**Tweed Shire Council Submission – Hanson Tweed Sand Plant Expansion -
State Significant Development (SSD-10398)**

I refer to the Department's request for Council's advice / comment on the proponent's most recent RFI Response for the Hanson Tweed Sand Plant Expansion (SSD-10398). Council officers have undertaken a review of the proponent's RFI Response and supporting documentation and provide the following comments for the Department's consideration.

FIGURE 19: EXTRACTION PHASES

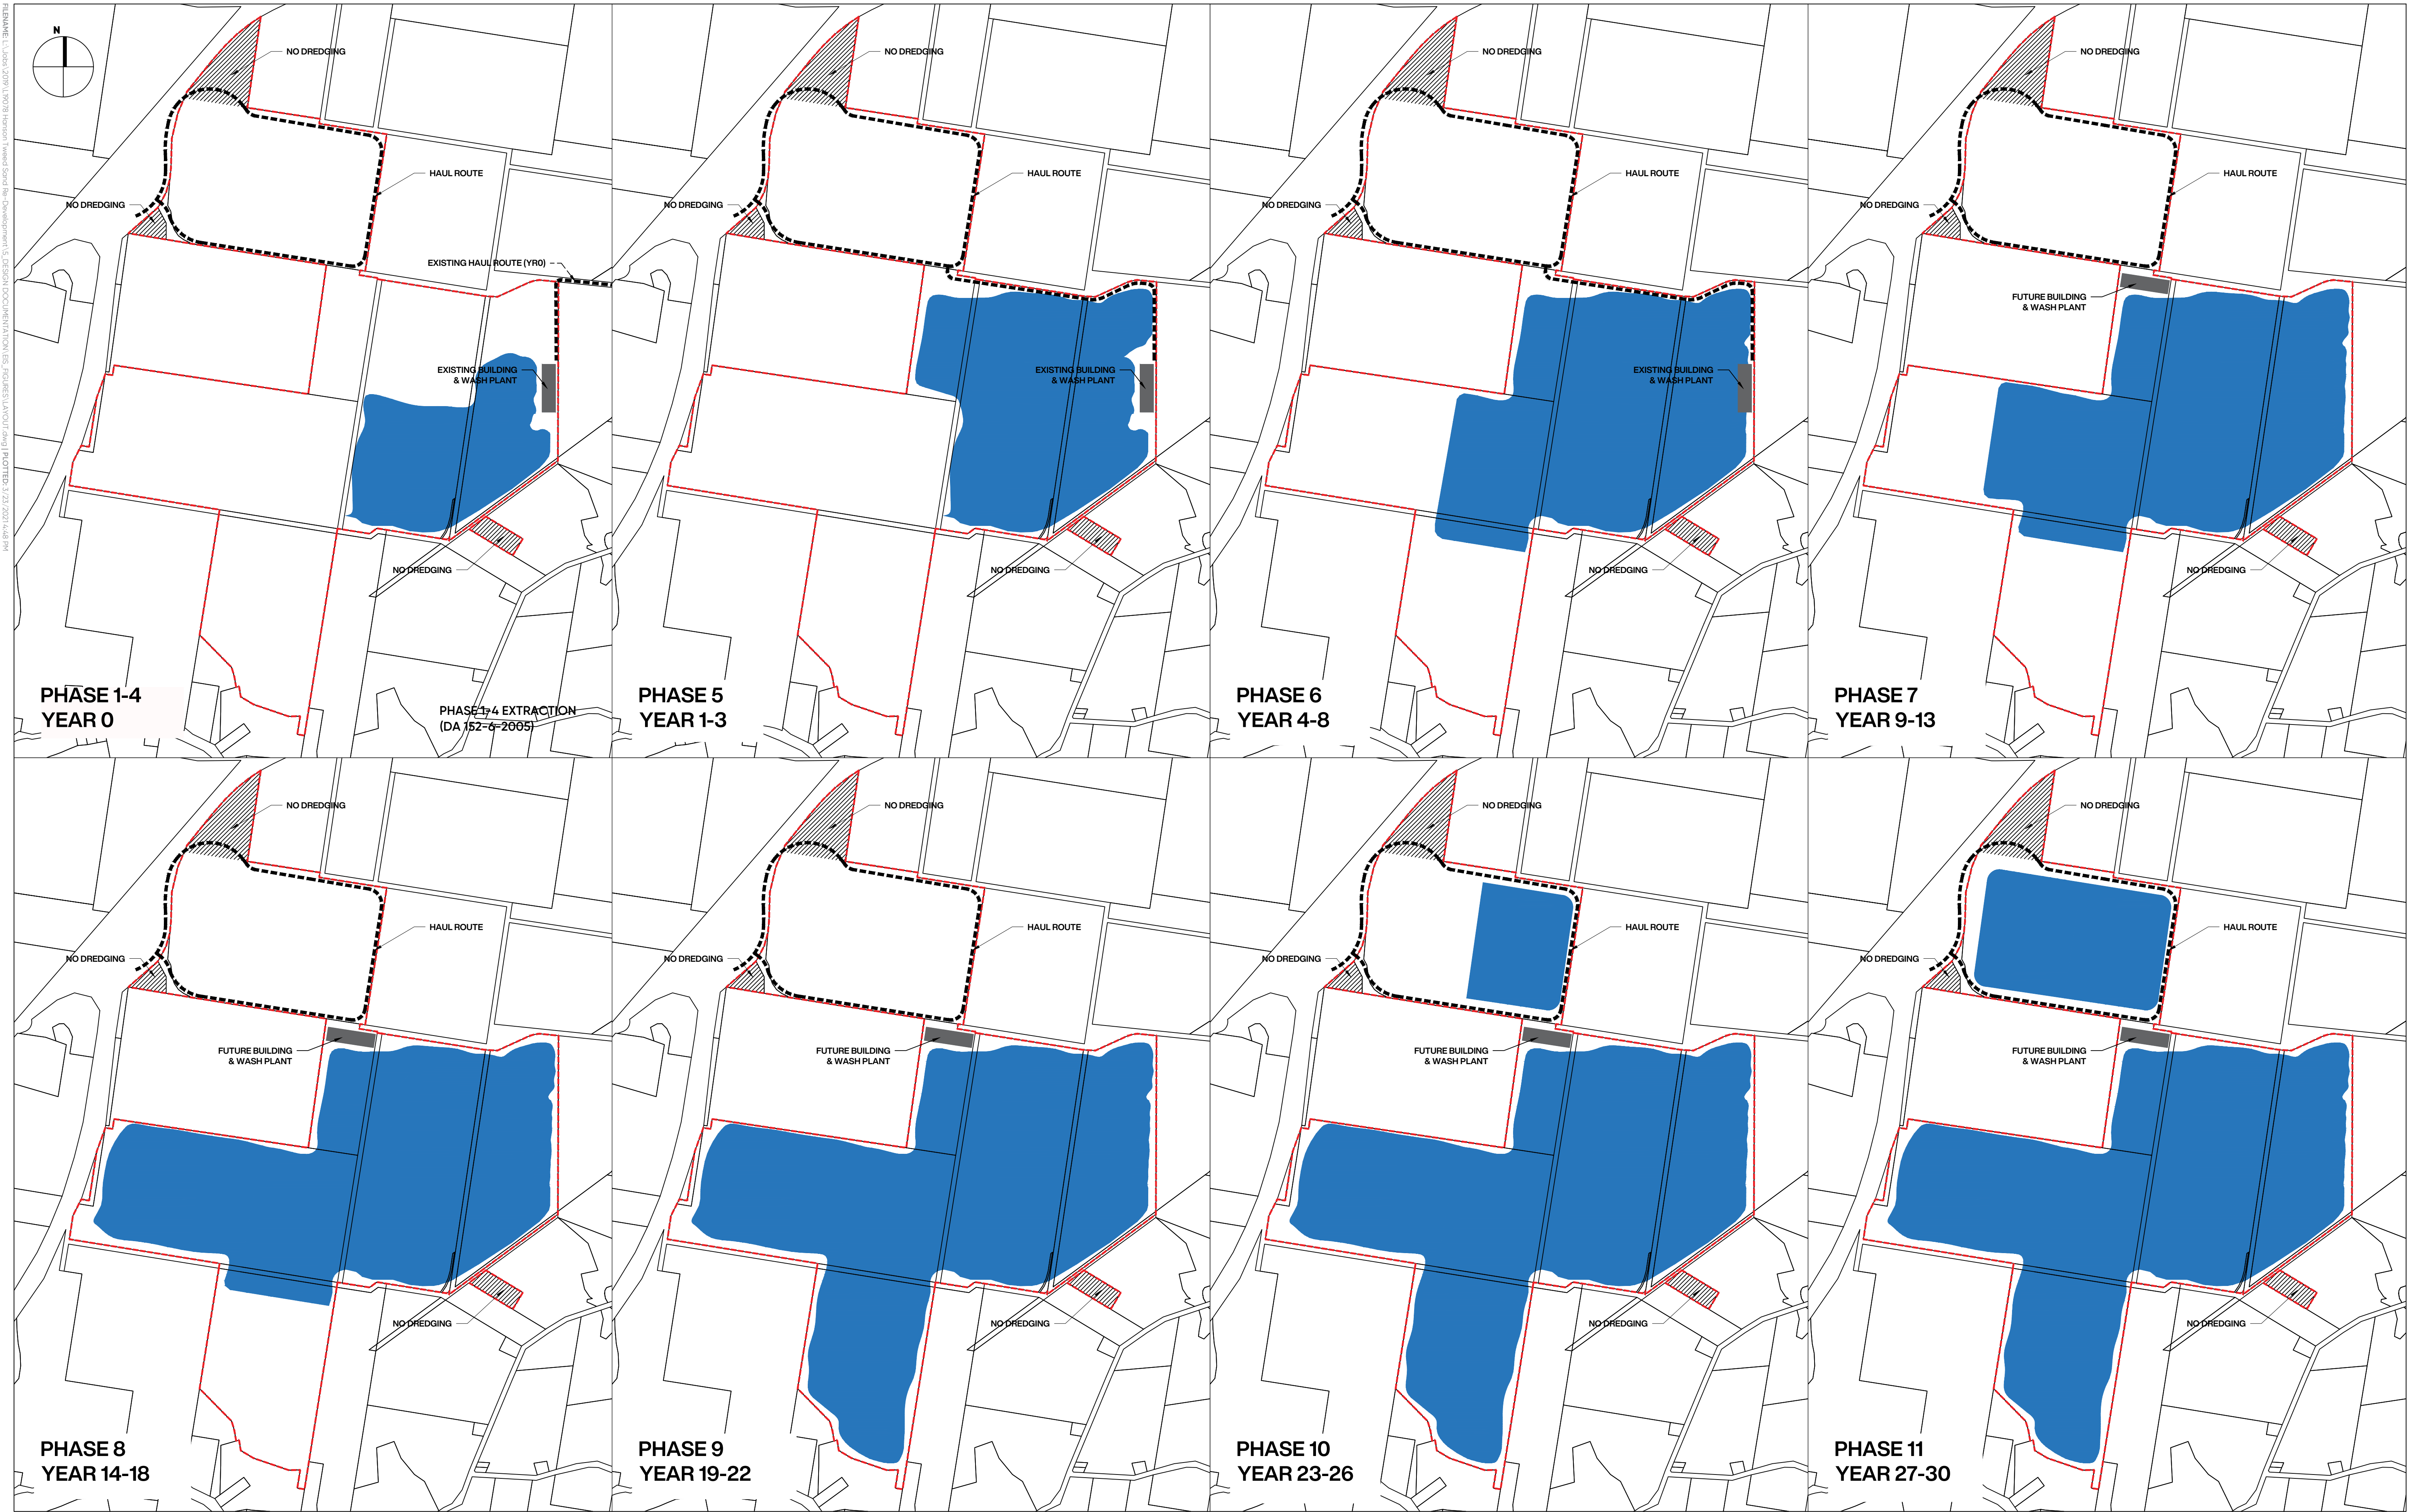
The proposed development incorporates an unnamed road reserve (located within Phase 5, Years 1-3 as highlighted in blue below), which poses a significant issue for the progress of the proposed development.

It is noted that the proponent's initial EIS states that a Road Closure and Purchase Application has been prepared and lodged with Council. As noted in Council's submission dated 19 August 2024 (under Item 13 dot point one), the closure and purchase of the unnamed road reserve adjacent to Lot 22 DP1082435 has not been approved by Council, as per Council resolution of 28 October 2021.

In addition, it needs to be highlighted that owner's consent has not been issued by Council for the use of the road or for any sand extraction within the road reserve.

Without any form of owner's consent from Council in relation to the road reserve and given there is no certainty in terms of any future road closure / purchase application being supported by Council, it is considered that the Department is not able to lawfully apply a condition of consent in relation to the road reserve.

This being the case, the proponent would need to demonstrate how they intend to undertake sand extraction to the west of the unnamed road reserve, without impacting on the road itself.
